KITTITAS COUNTY

MEMORANDUM

TO: All Staff
FROM: Public Works Plan Review Team
DATE: January 21, 2025
SUBJECT: BL-25-00002 Sageview

SAGEVIEW BLA/SHORT PLAT PART OF SECTION 29, T. 17 N., R. 20 E., W.M. KITTITAS COUNTY, WASHINGTON

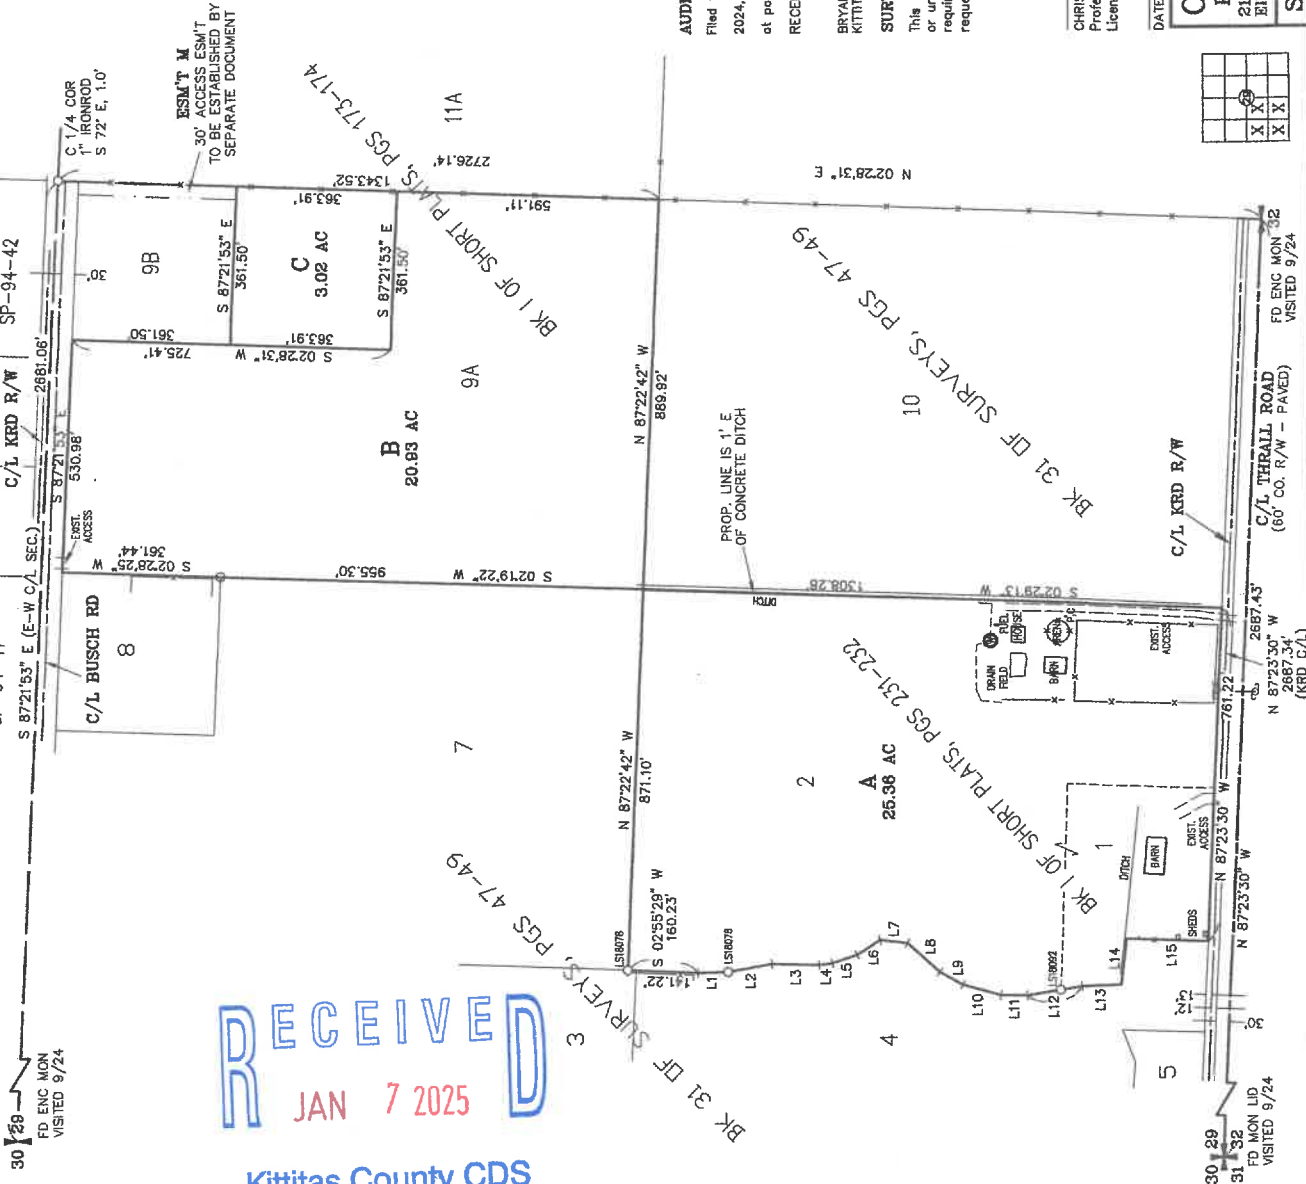
<p>property will be viewed as being subject to short plat standards, and will be treated as such.</p> <ol style="list-style-type: none">4. Sheet 1 – Please clearly show a note similar to the following: “This sheet represents adjustment to boundary lines prior to Short Plat recorded simultaneously and shown on subsequent pages”.5. Sheet 1 – Please show the following note (or something similar) on Lot A: “Lot A is a transitional parcel to be further subdivided on subsequent pages and should not be referenced as a unique legal lot after recording”.6. Sheet 1 – Please identify previous and proposed boundaries.7. Please set and show corners per Short Plat standards.8. Sheet 2 – Elevation Datum note contains minor typo.9. Please include a survey narrative explaining the BLA and simultaneous Short Platting.10. Final document shall be filed as a short plat. All lots shall be referenced as being a portion of a short plat.
